Re: Site Plan II Application Response to Comments  
Proposed Taco Bell, 1363 Washington Ave, Portland, ME

On behalf of the applicant, Guggenheim Retail Real Estate Partners, Inc., VHB has prepared the following responses to the review comments received from the Department of Public Works and Planning Department, dated February 11, 2016 and the Stormwater Peer Review, dated February 15, 2016 for the conversion of the existing Sala Thai restaurant to a Taco Bell facility. Please find the following materials included to accompany the responses:

Drawing Title
Planting Plan

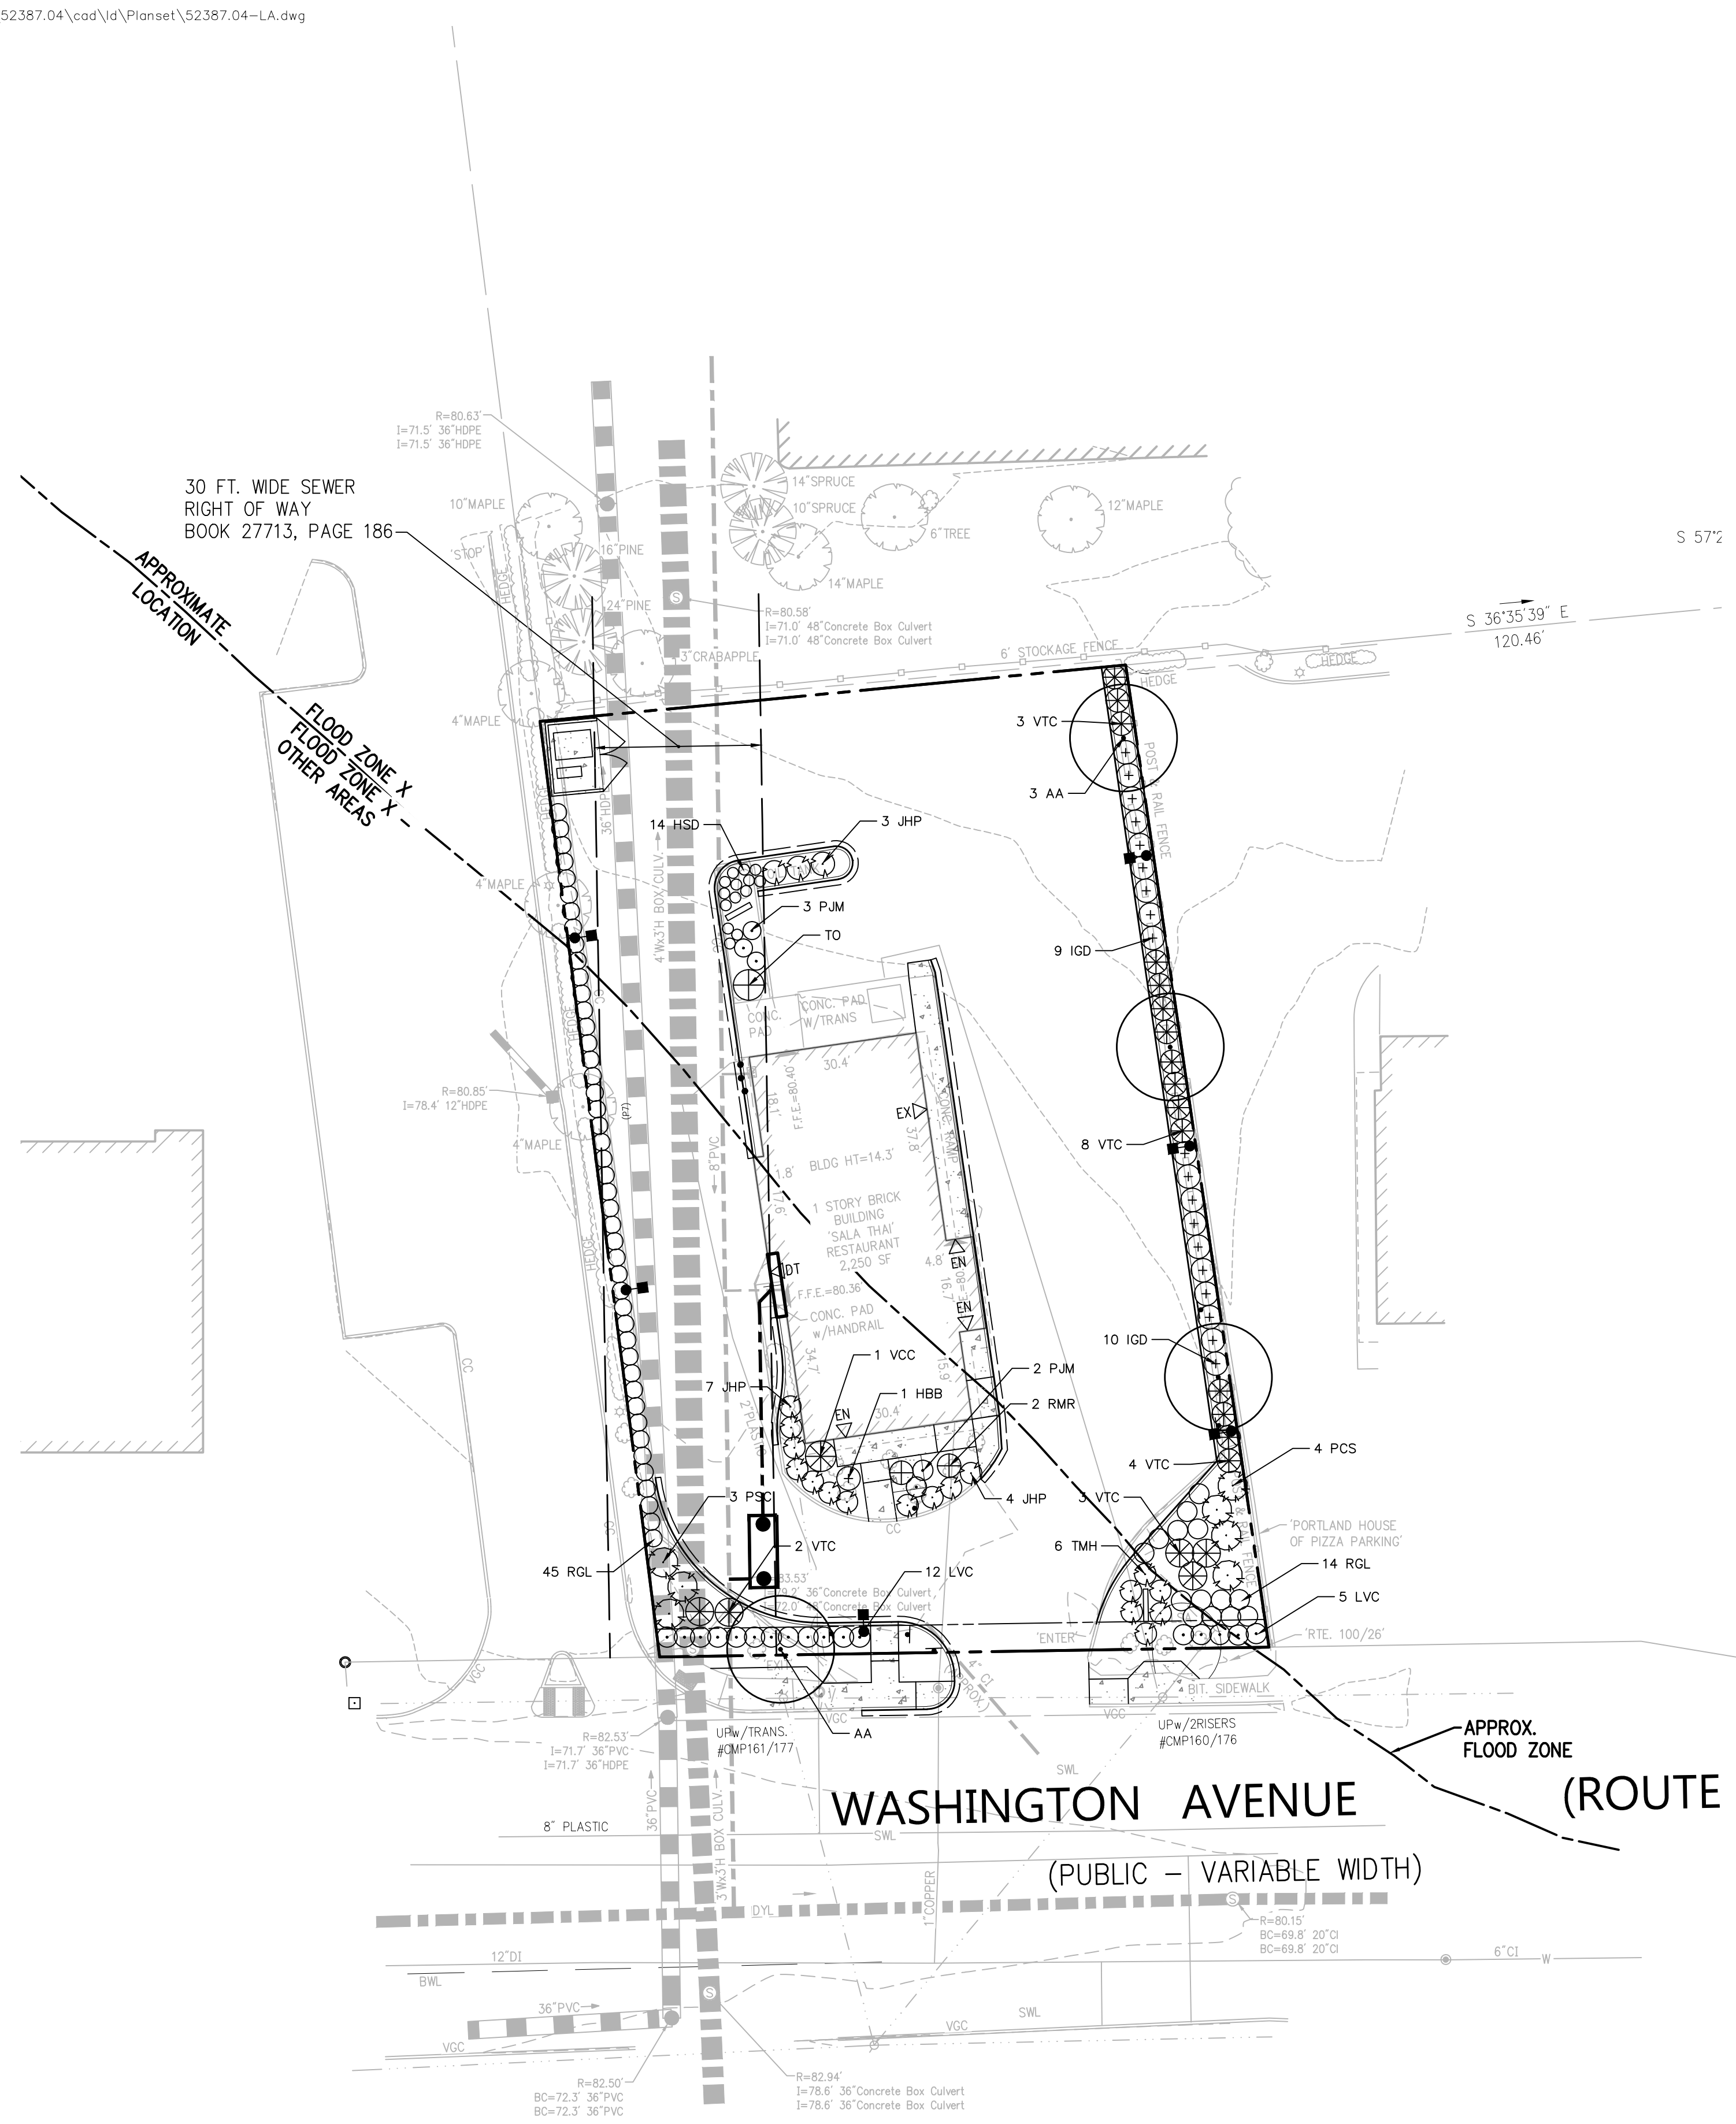
2. *Landscaping and B2 Design Standards re screening: the entire site is subject to landscape and screening standards and there are also street tree requirements - please see 14-526 (b) 2b Environmental Quality Standards (attached) and the B2 Design Standards para 8 (attached). There is also guidance in the City's Technical Manual (Section 4) which is on the Website at <http://www.portlandmaine.gov/documentcenter/view/2211> The City Arborist will be reviewing the plan and may suggest specific improvements, but I think this might need to wait until the access question is resolved. In any case the dumpster would need to be enclosed and parking lot landscaping be enhanced; snow storage areas should be identified.*

The landscape plan as presented meets the requirements of site landscaping in Sec. 14-526 (b) 2b. Dumpsters and service areas are proposed to be screened and will not be visible from the street or adjacent properties. Required understory (shrub) plantings exceed required plantings significantly. The landscape screening between adjacent properties and this site have been shown on the plans. These consist of an enhancement of the northerly buffer with shrub plantings,

maintaining the existing 6' stockade fence at the easterly property boundary, and installation of shrub and tree landscaping on the southerly property boundary. Parking lot trees are shown in the landscape island on the southerly boundary of the site.

A street tree has been shown on the plan. This tree is not shown in the Washington Avenue ROW, as there are overhead utilities that interfere with planting in this location.

**Not Approved for Construction**  
 Drawing Title: **Details**  
 Drawing Number: \_\_\_\_\_

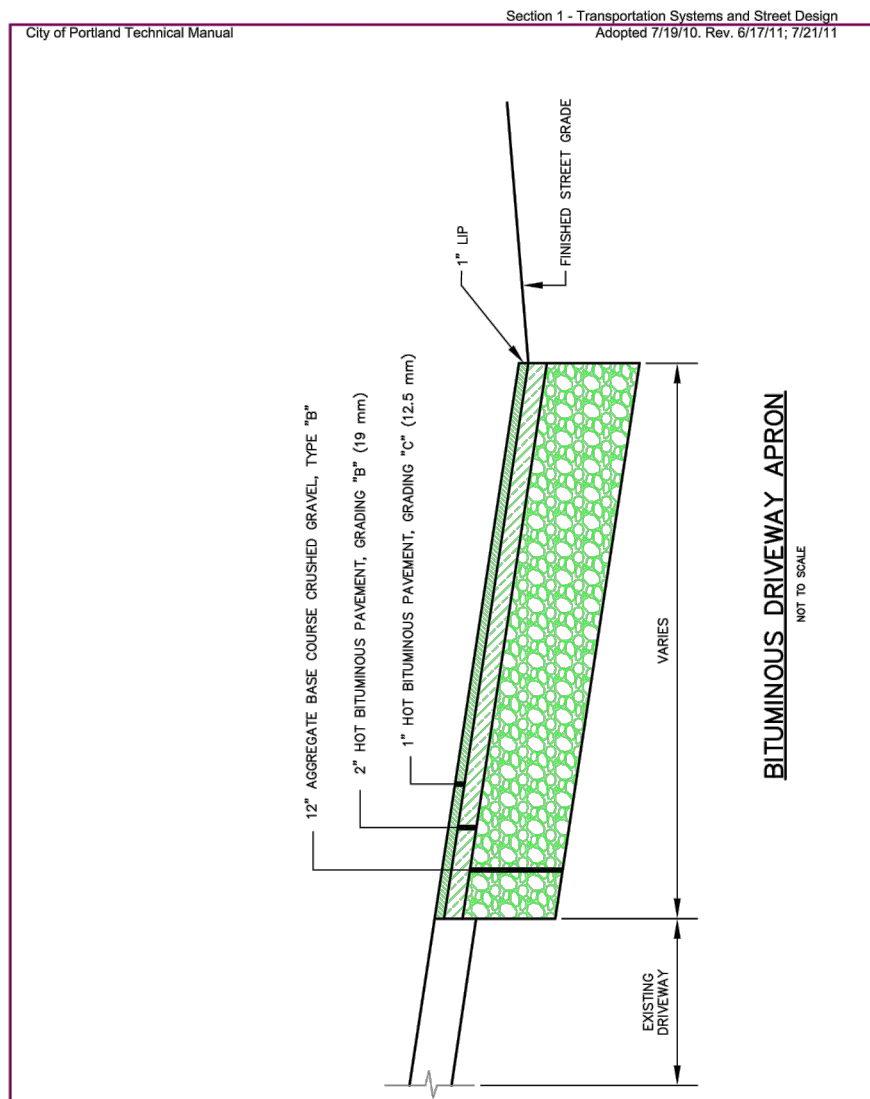
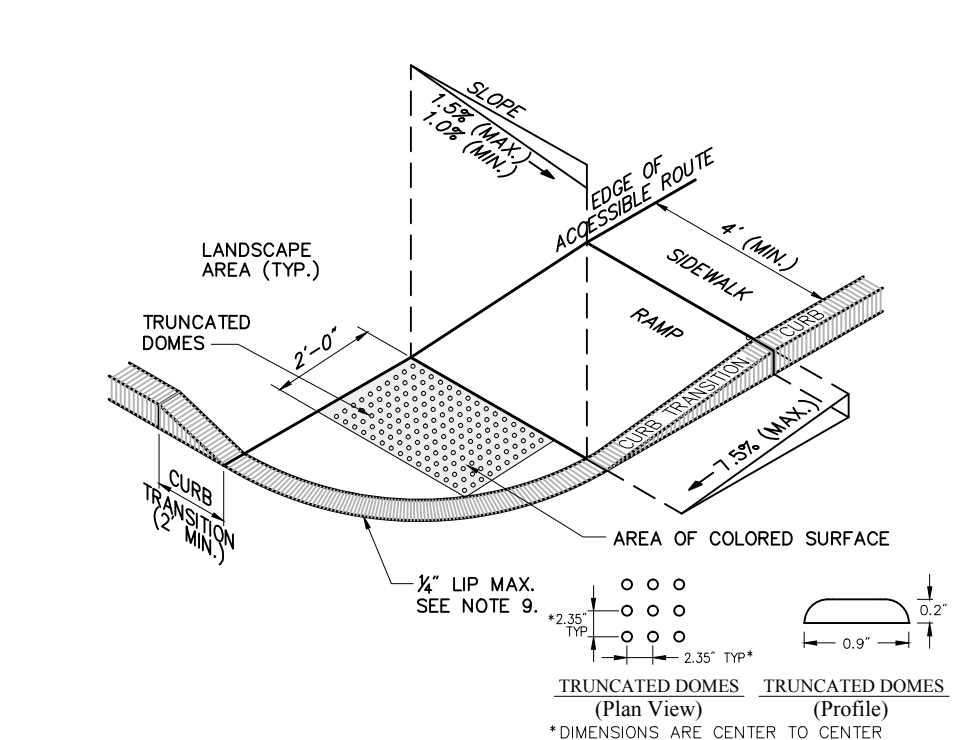
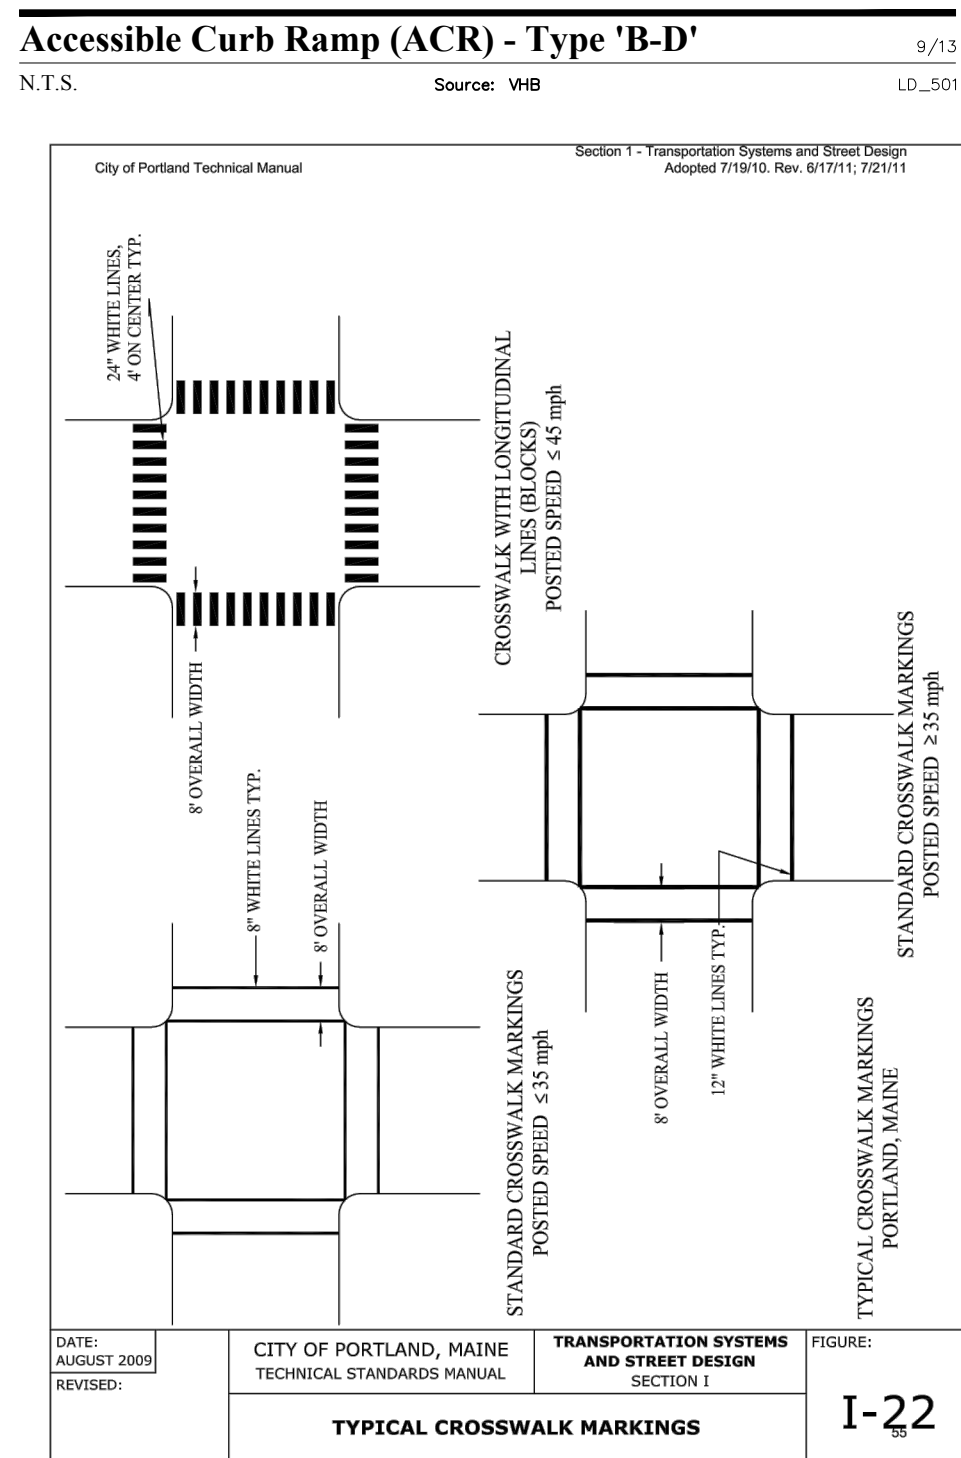
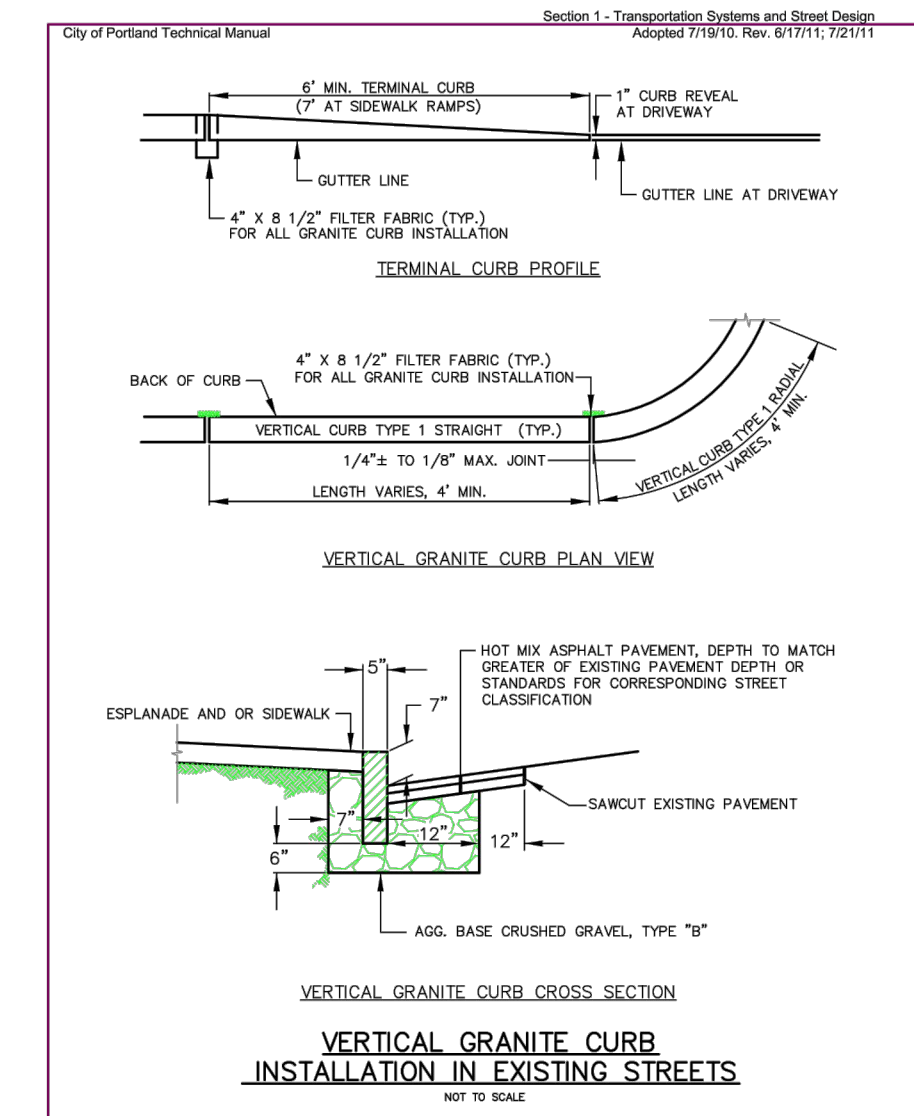
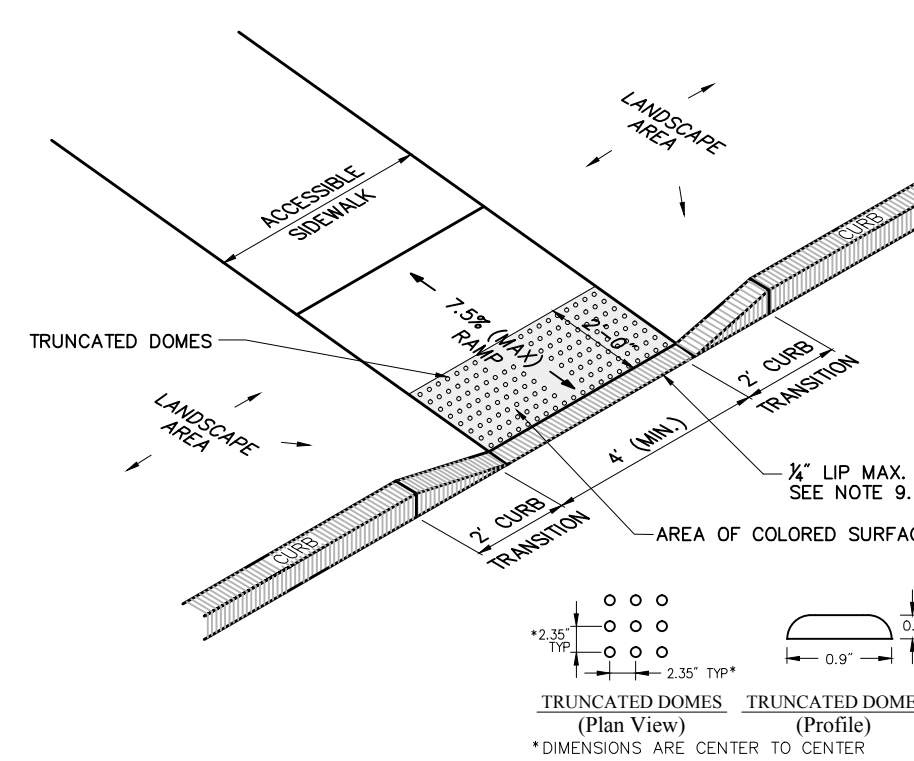
5. *Details associated with all work proposed within the City Right-of-Way should be revised to comply with the City of Portland Technical Manual; these details include:*

- a. *concrete sidewalk;*
- b. *granite curbing;*
- c. *pavement repair in the ROW*

City specific details have been added to the Detail Sheet for associated work within the right-of-way.
